Application Number: 2014-053 Application Date: 04/15/2014
CBL: 012 E006001 Application Type: Level III Site Plan Under 50,000 sq f
Applicant: Avesta Washington Ave. /Greg Payne
Project Name: Washington Avenue Efficiencies
Address: 134 WASHINGTON AVE
Project Description: Development of 18 affordable housing units in a 4-story building
Zoning: B2B/R6

MEMORANDUM

Subject: Application ID: 2014-053

BOUNDARY & TOPOGRAPHIC SURVEY
AT
134 WASHINGTON AVENUE, PORTLAND, MAINE
MADE FOR
AVESTA HOUSING DEVELOPMENT CORP.
307 CUMBERLAND AVENUE, PORTLAND, MAINE

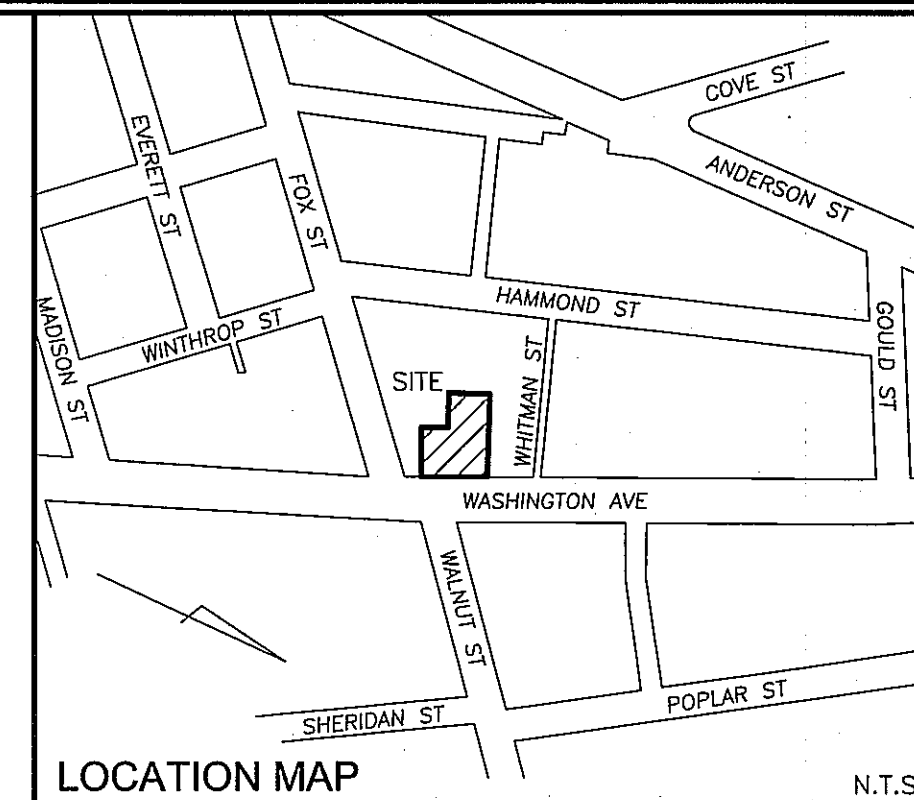
I also noticed that the lot for this project is bisected by R-6, and you're comments are included in my still-developing review memo. What I don't know is how a lot split by two zones should account for applicable dimensional standards. Are setbacks and impervious surface maximums for R-6 applicable to the rear of the lot, or does B-2b override the split in this case? Any feedback you have is much appreciated.

this project is in a B-2b zone with an R-6 zone in the rear. I have a few questions. Are the footings underneath City Property in front? I would like confirmation that the right side setback is the minimum of 5 feet. The lines on the plan translate into about a foot wide. I would also like to confirm the height be getting the average grade around the building. There are several point that are much lower than where the measurements are labeled. I would also like confirmation on the parking in lieu numbers that relate to this property.

Bird 1: Regarding 134 Washington Ave, we interpreted the zoning line to be at the lot line and did not see the gray scale of the lot line extending into the R6 zone. How is the B2b zone established on Washington Ave, is it an offset from the centerline of the street or edge of right of way. We are trying to figure out how to establish the line on the revised plan.

I believe that section 14-51 of the Ordinance allows an extension of the less restrictive zone (B-2b) into the more restrictive zone (R-6). The widest portion of the R-6 zone is about 24' by measurement and would meet the definitions of 14-51. So in essence all of the lot is B-2b for all the requirements.
